Application for a non-material amendment following a grant of planning permission.

Demolition of existing dwelling and erection of 34 bungalows for the over 55s with associated access, parking, landscaping and open space

3/2018/0008

Non material amendment to the kitchen door layout

site:	Croft Butts Lane Freckleton
title:	Bungalow Type B Floor Plan

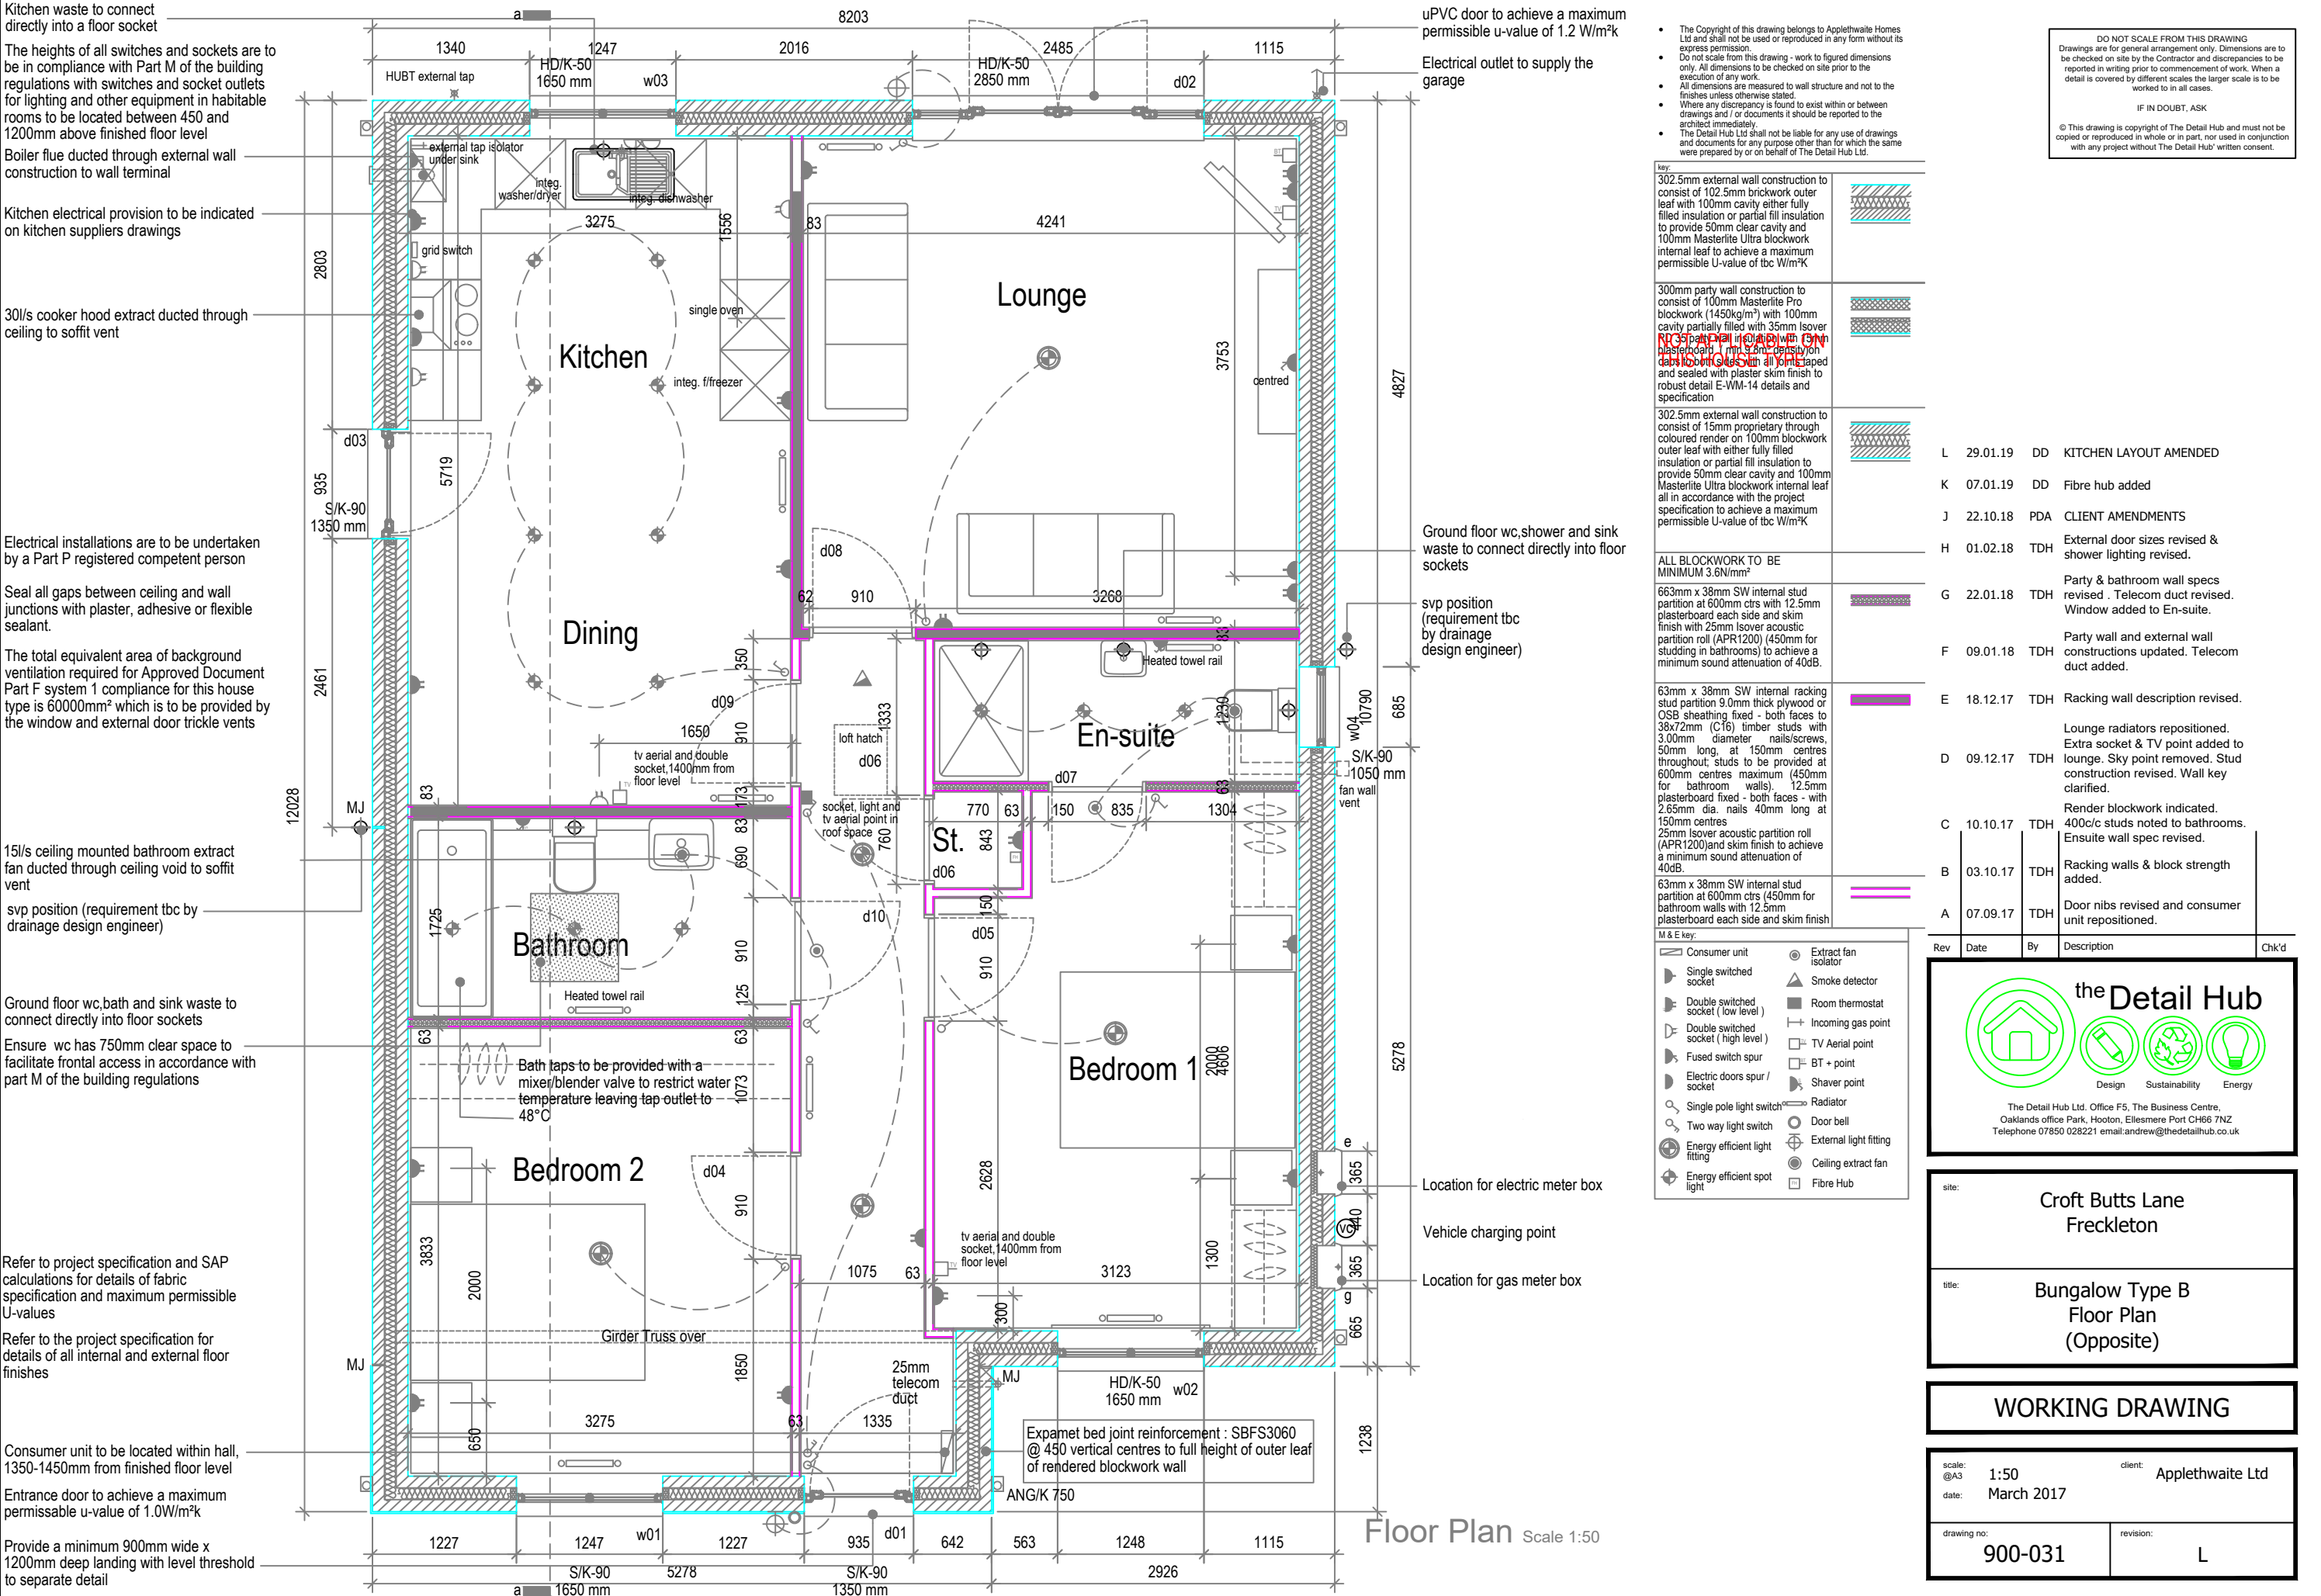
Bungalow Type B_Rev J

Bungalow Type B_ Rev L

Kitchen door location amendment to Housetype B
